Re: **Framing Issue**
Location: Lot 6 Griffon Pointe (125 Grand Griffon Way (Lillington, NC))
JDS Project No.: RDU2304005
Date of Inspection: 05/24/2023

A representative of JDS Consulting arrived on site to observe the issues reported to us by the client, which are presented, along with our recommendations, in this report.

SHEET NO.
S4

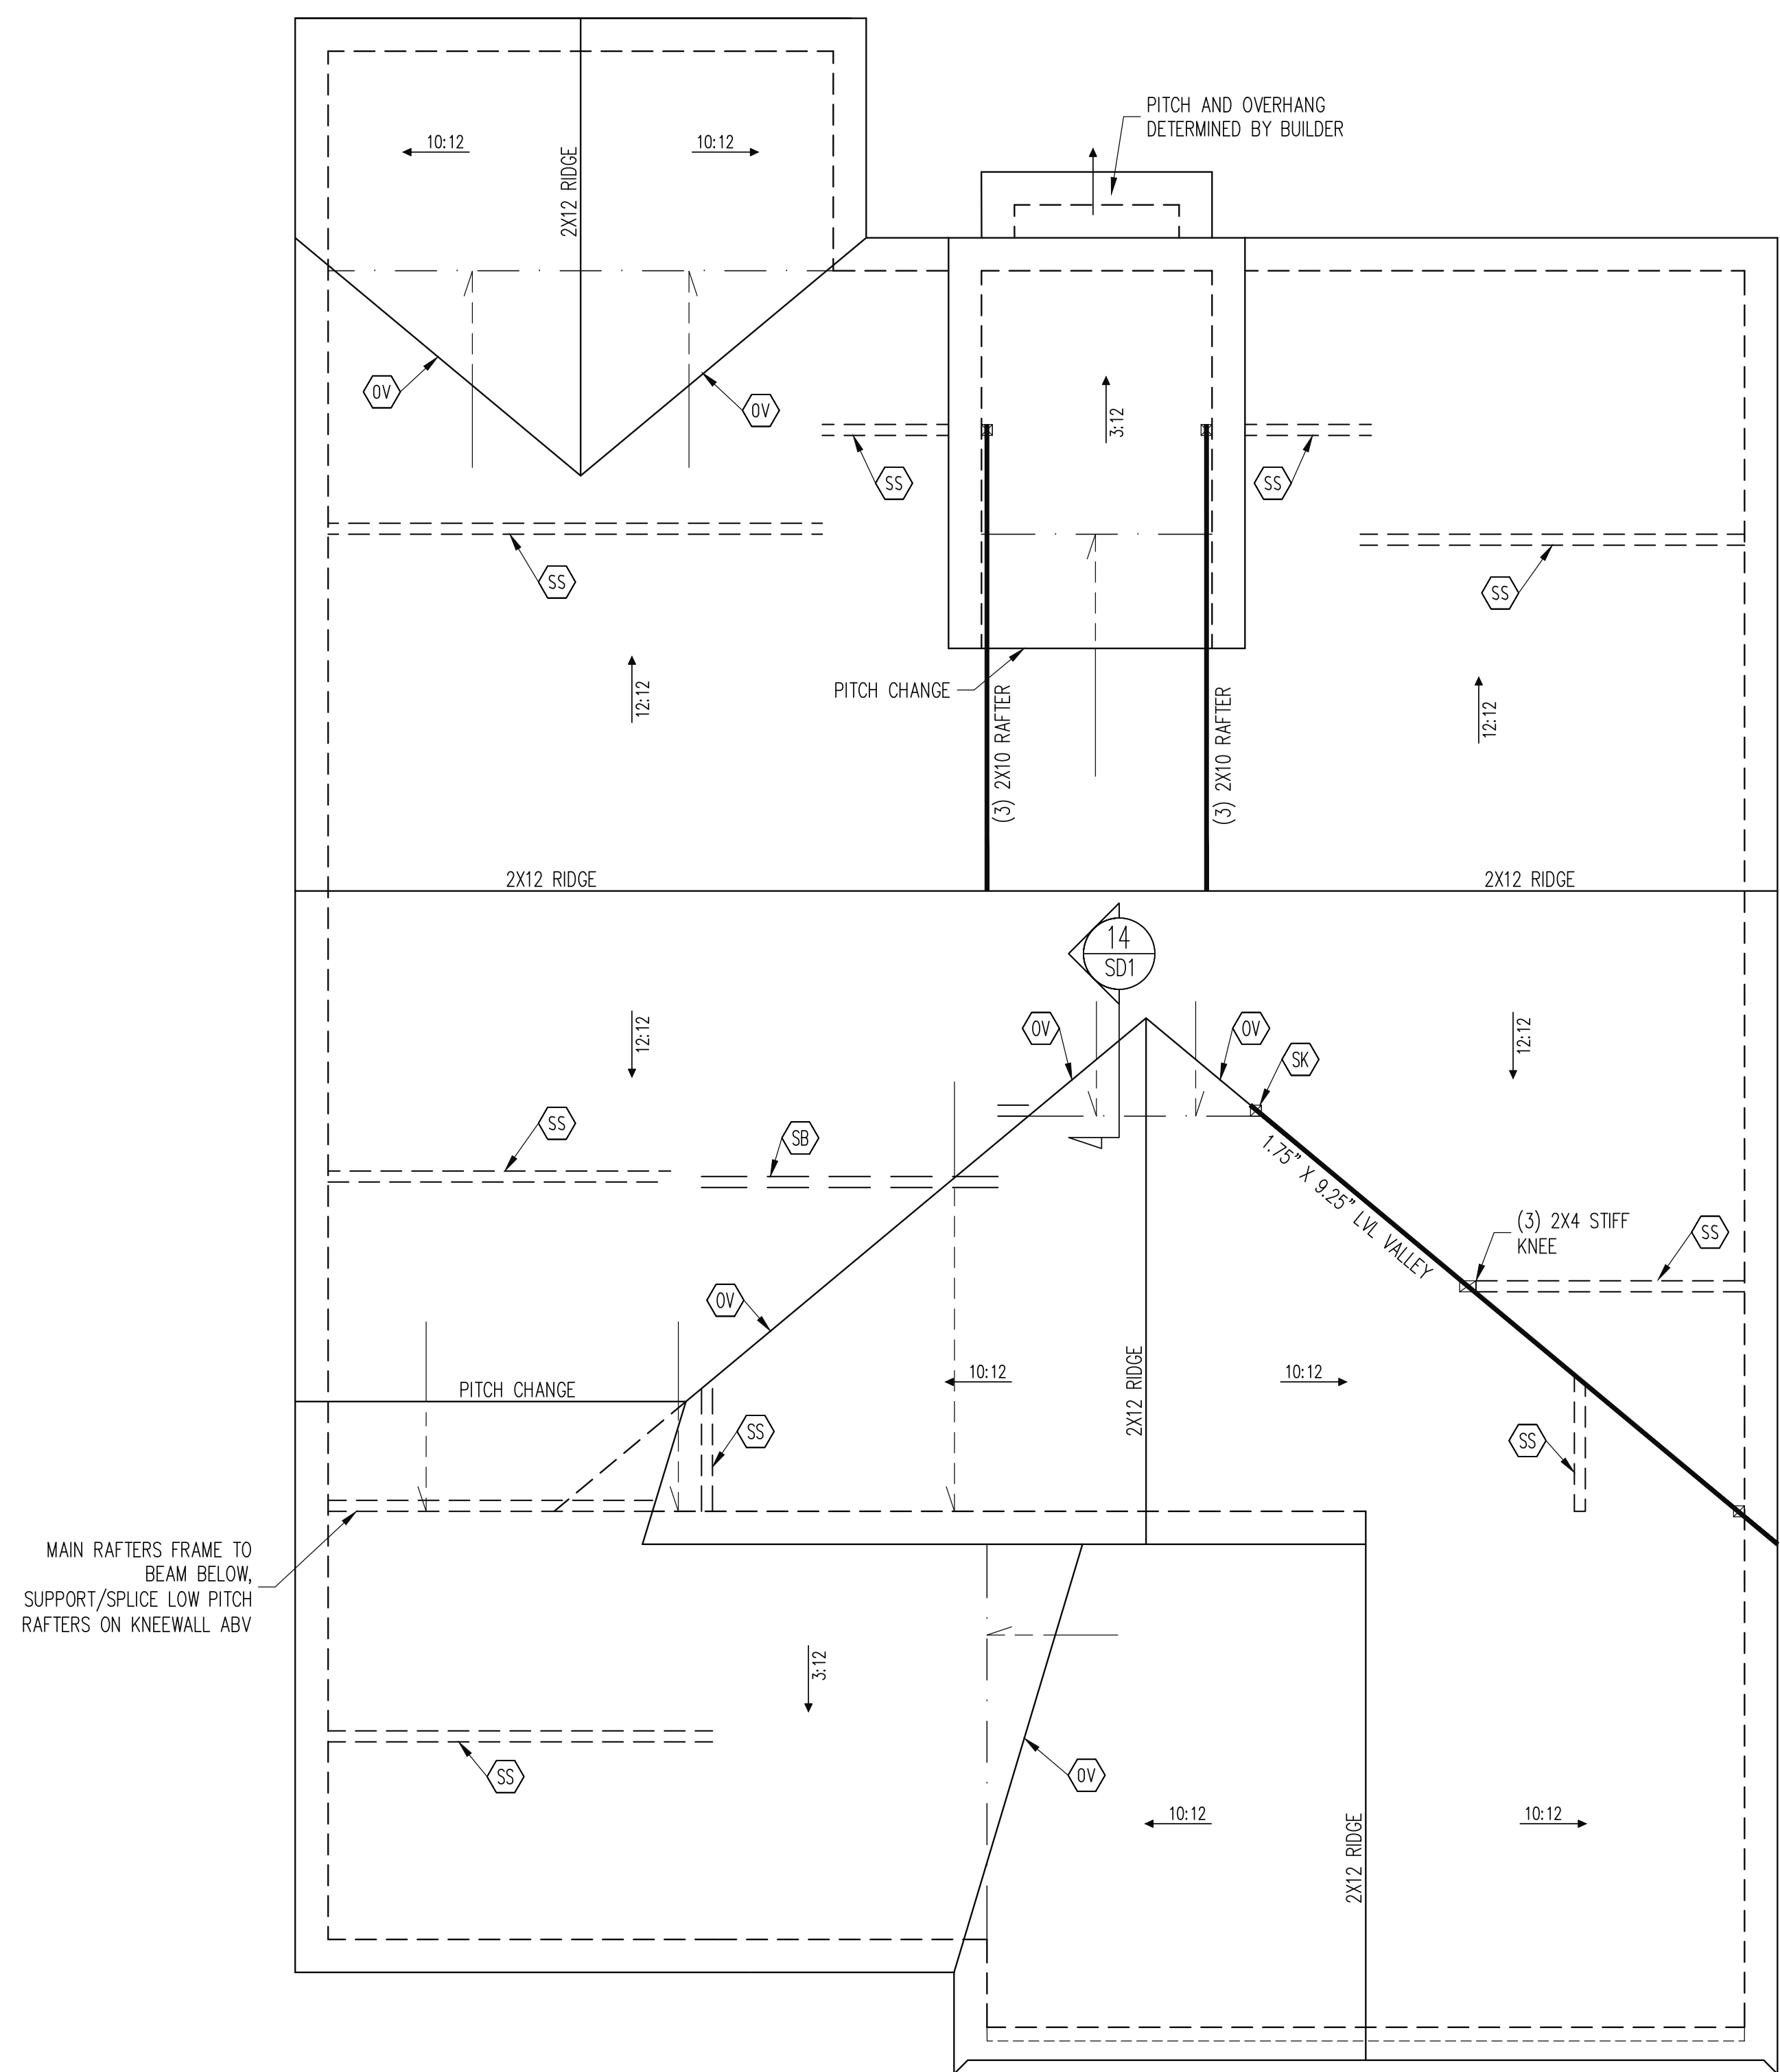
1. At the rear left attic/storage, the contractor installed a (2) ply 2x8 beam supporting the rafters and installed a (2) ply 1-3/4" x 4-1/2" LVL supporting the 12'-6" long 2x8 ceiling joist.
2. The contractor installed (1) 2x10 ridge beam through the house with a 2x material beneath the ridge to fully support the 2x8 rafters instead of installing a 2x12 ridge beam per sheet S5 of the building plans.
3. The (1) ply 1-3/4" x 9-1/4" LVL valley above the front right attic/storage is approximately 2-1/2" bearing on the top plate, beneath the top plate the contractor installed (4) 2x4 stud column.
4. The contractor requested an evaluation of the nails installed at the hangers; the contractor installed 1-1/2" long 10d nails.

1. The contractor installed a (2) ply 2x8 beam supporting the rafters per sheet S4 of the building plans, and the (2) ply 1-3/4" x 4-1/2" LVL mentioned above is adequate for the loading conditions. No further action is required.
2. The 2x10 ridge beam is adequate as installed provided the rafters are fully supported. No further action is required.
3. The LVL valley mentioned above has a sufficient bearing area for the loading conditions. No further action is required.
4. The nails mentioned above are adequate to fasten the hangers to the headers, however, the contractor shall remove the nails installed into the shear locations at the 2x joist and the LVL and install 0.148 x 3" nails per the manufacturer's installation instructions. Ensure hangers are installed flush with the joists.
